Planning Inspectorate

Case ref: EN010158

Application by Rosefield Energyfarm Limited for an order granting development consent for the Rosefield Solar Farm

Advice following issue of decision to accept the application for examination

**SHEET 4 OF 8**

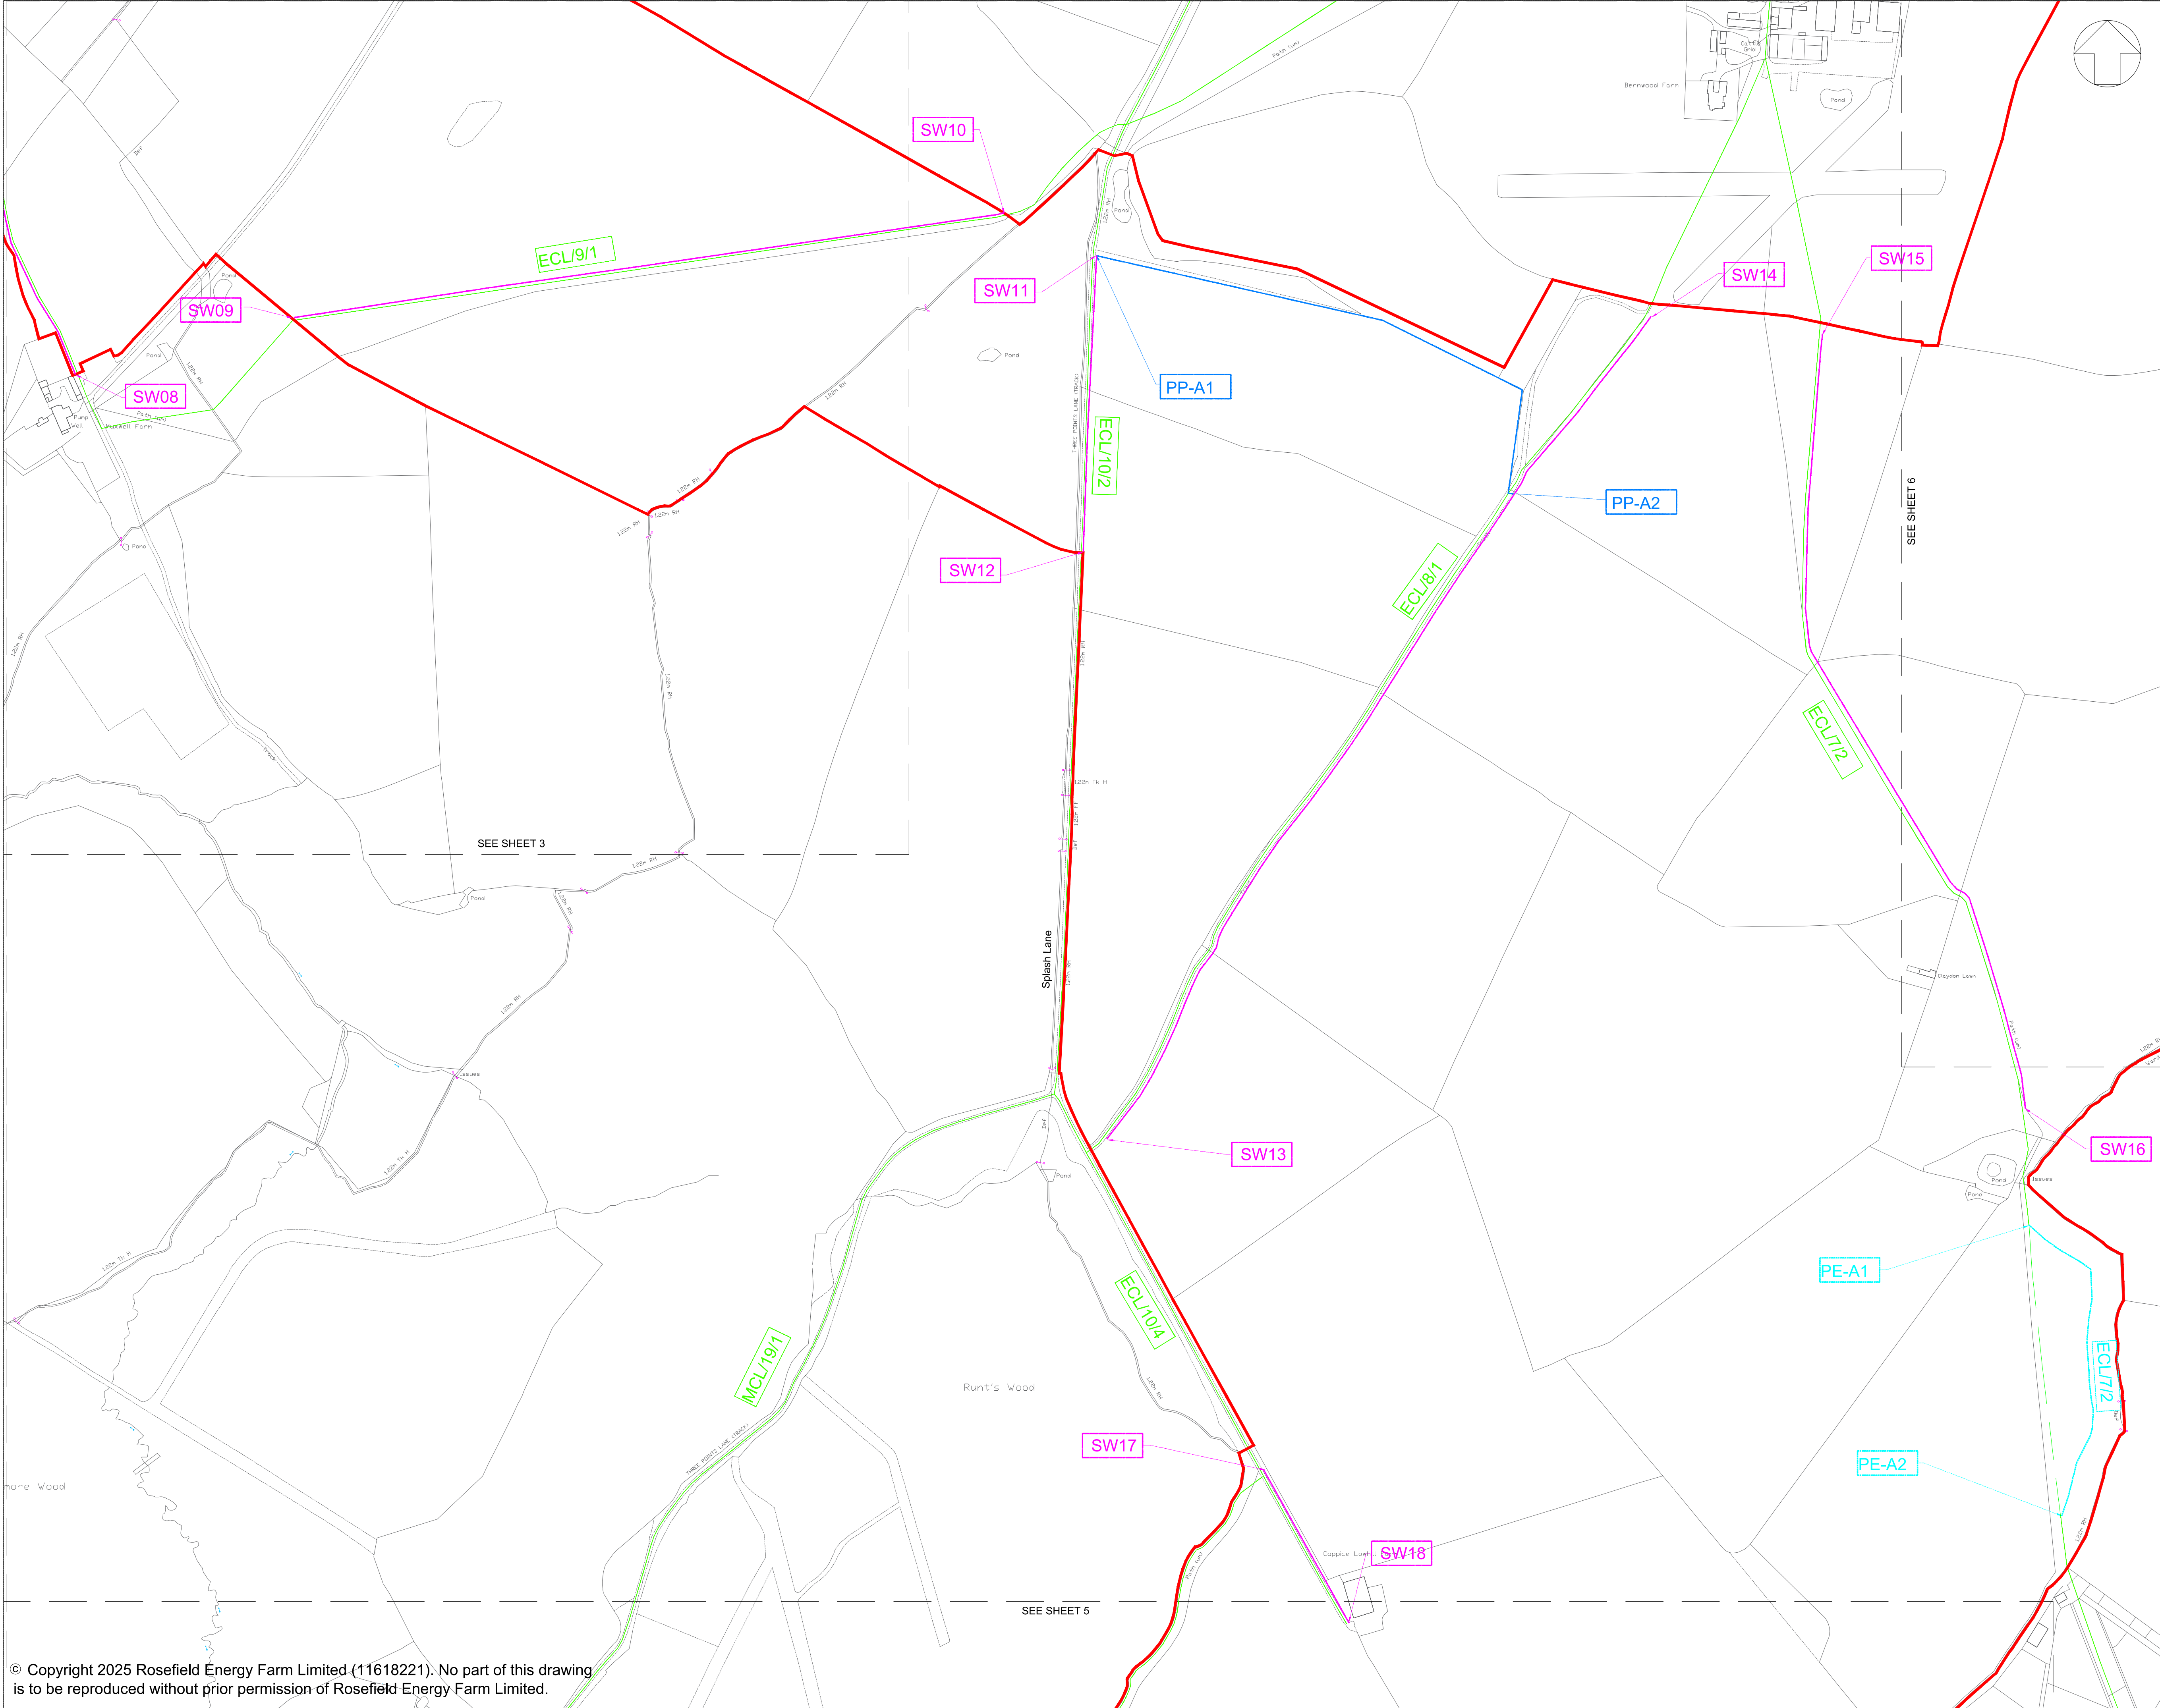
The **Streets, Rights of Way and Access Plans** (Doc 2.4) is missing works ECL/7/3 between points SW15/SW16 which is mentioned in the draft Development Consent Order. Also on sheet 4, the plan shows ECL/8/1 but the draft Development Consent Order states ECL/8/11.

TITLE:
FIGURE 3.1.2A
HEIGHT PARAMETERS - KEY PLAN

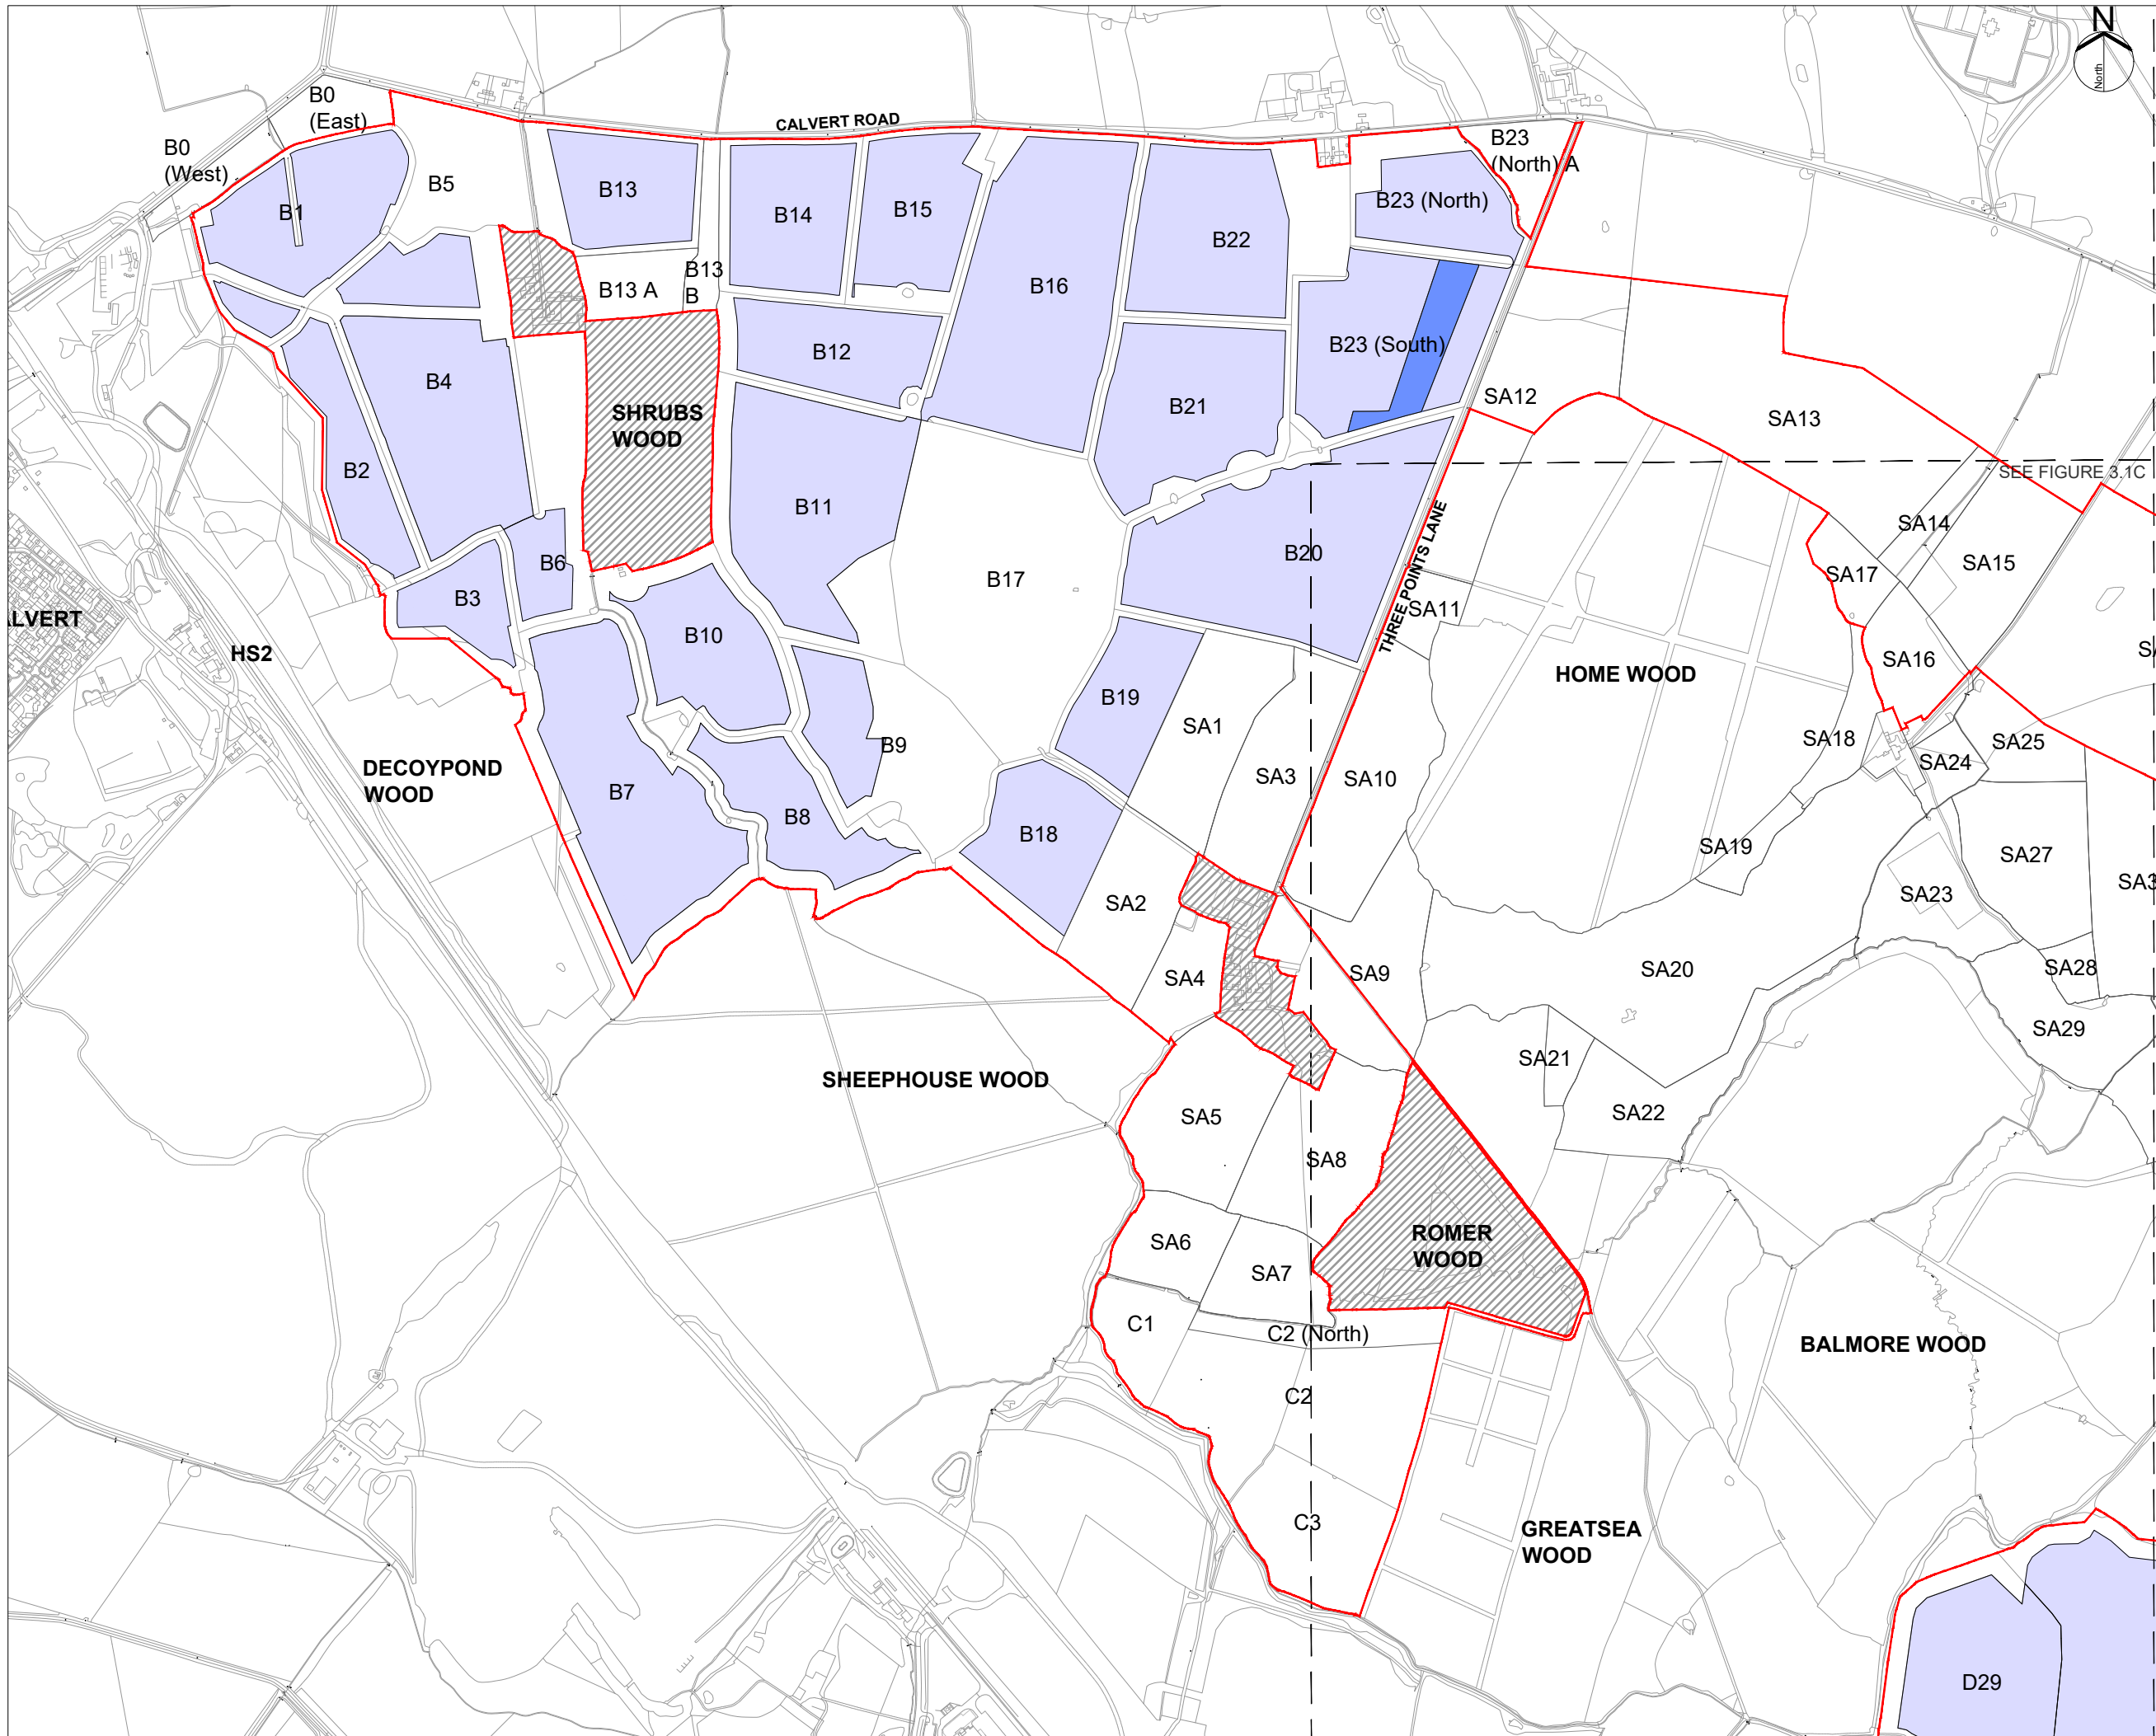
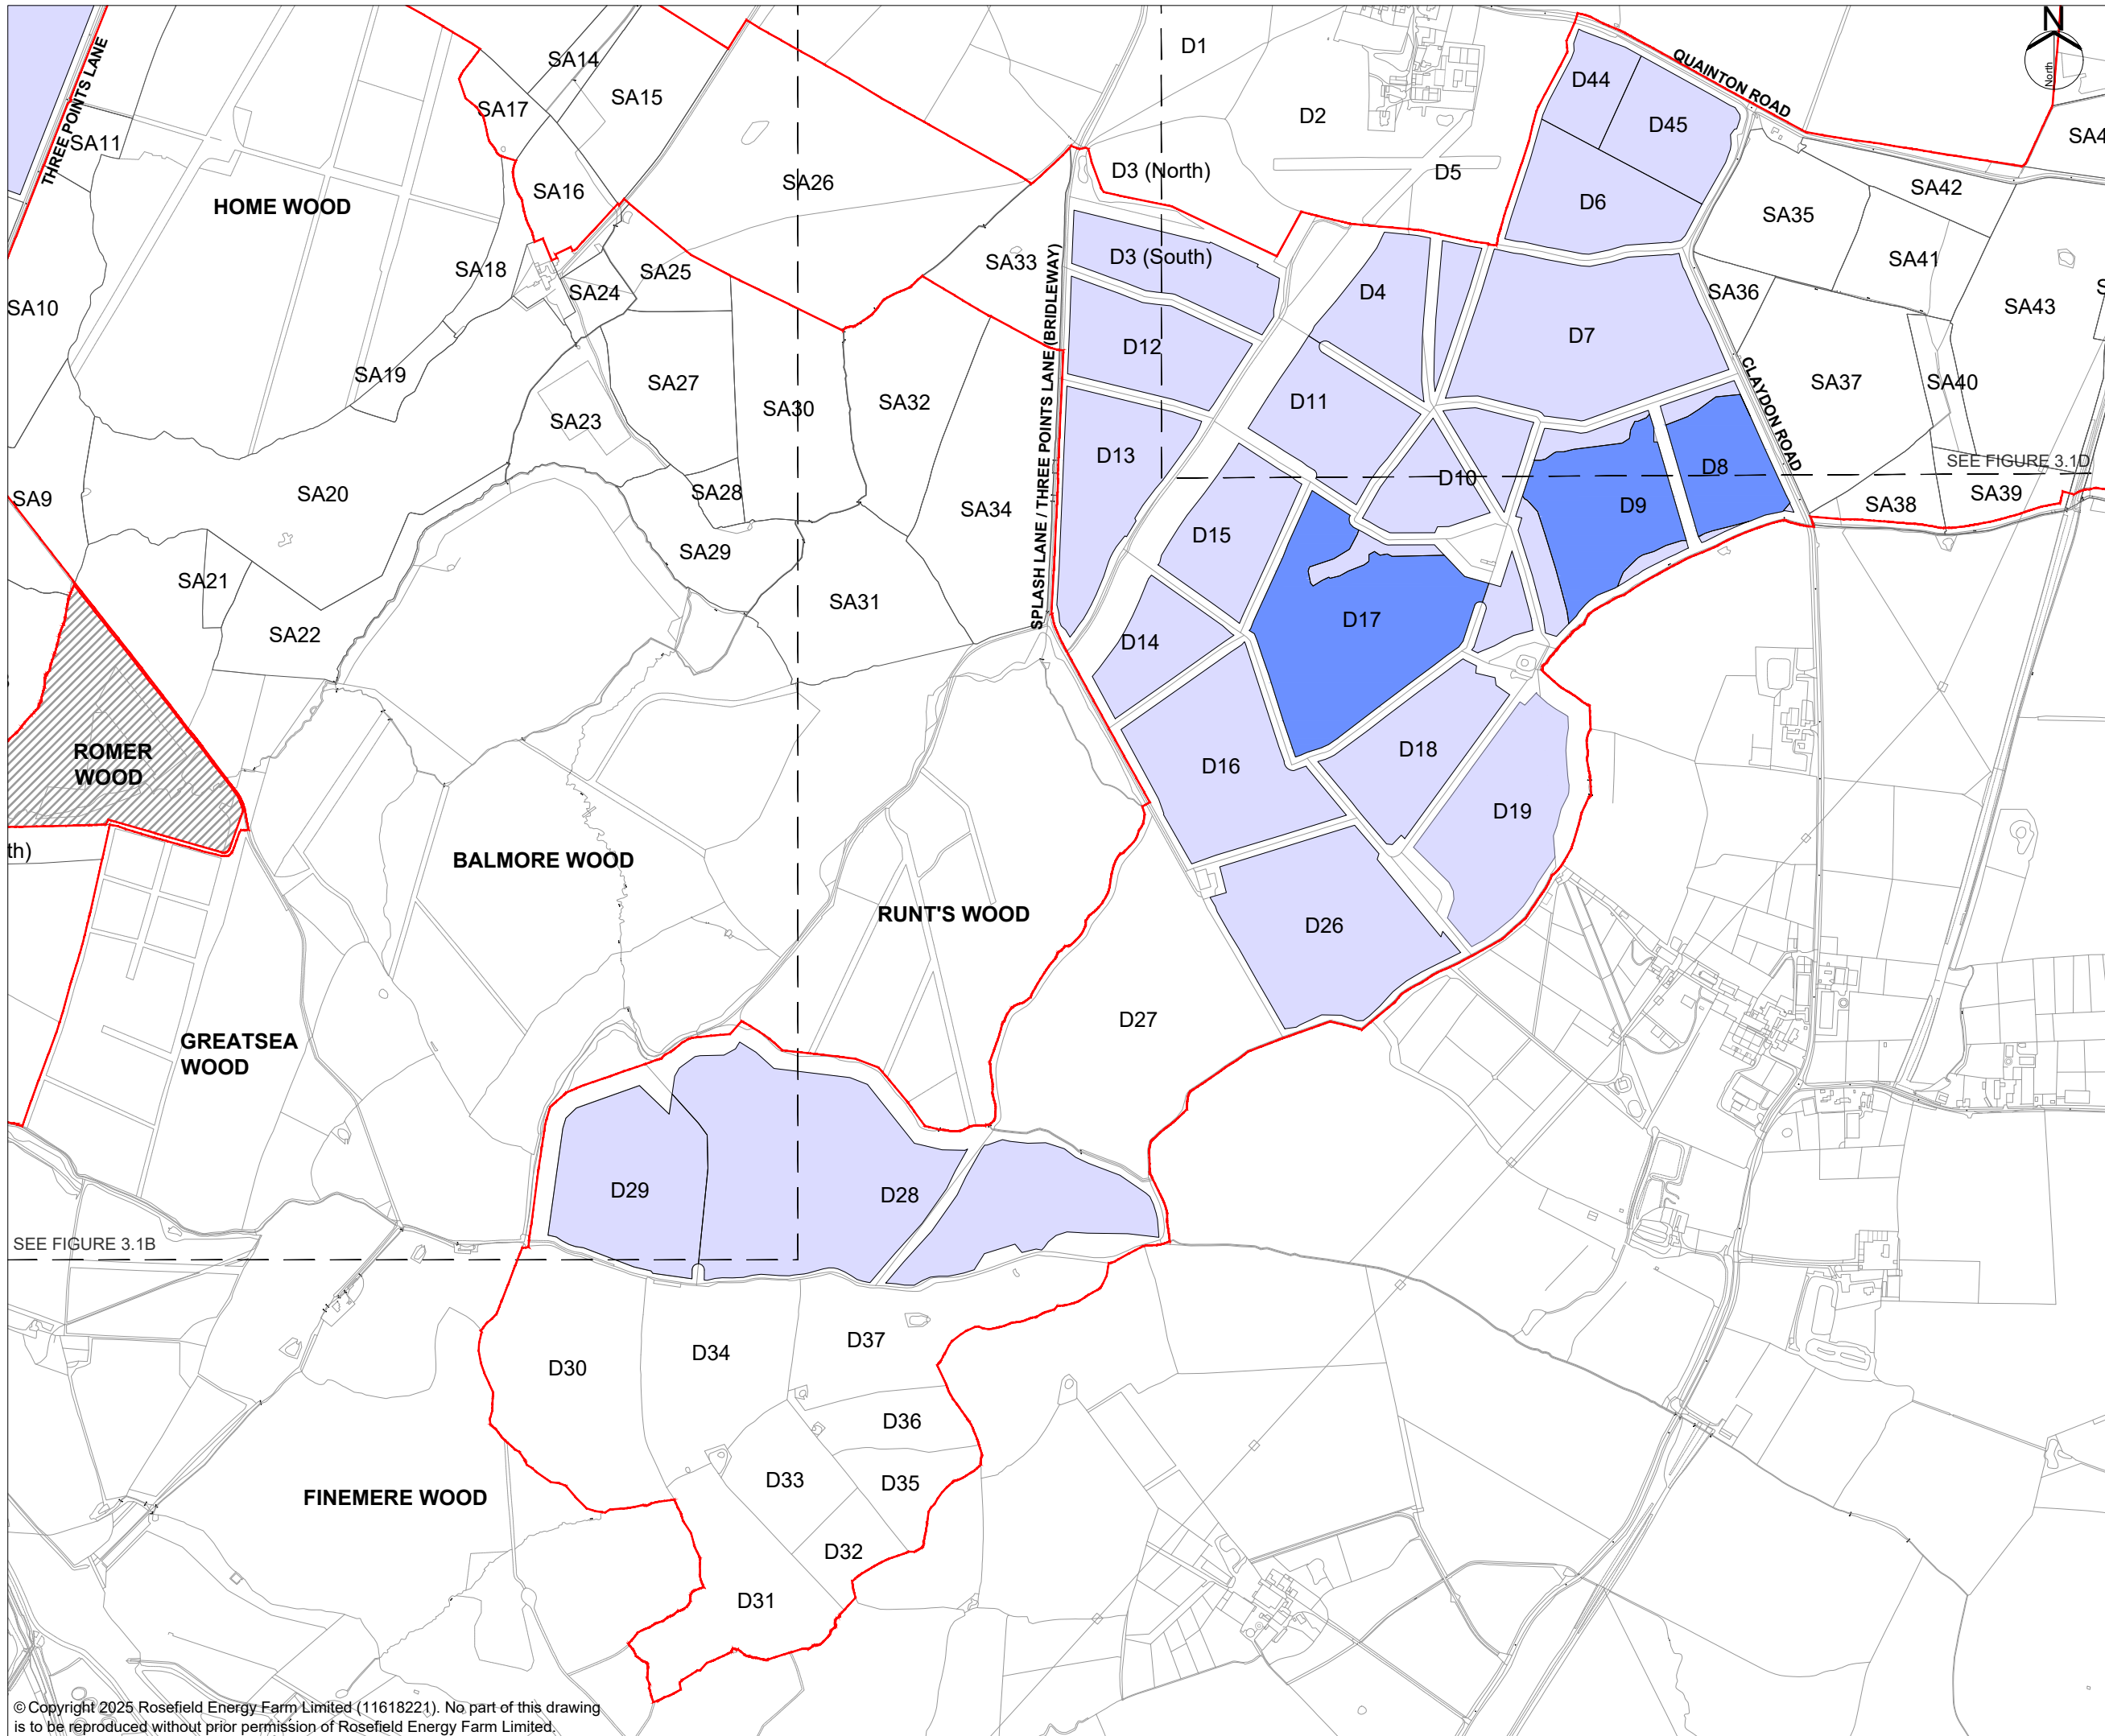
It is difficult to differentiate between ALC grades as presented in **Volume Chapter 12: Soil Figure 12.1** (Doc. 6.3) due to the shading used. Similarly, the shading applied in Volume 3 Chapter 3: Proposed Development Description Figures 3.1A – 3.1D makes it difficult to distinguish between proposed development heights of up to 6m from those of up to 15m. Please update the plans accordingly.
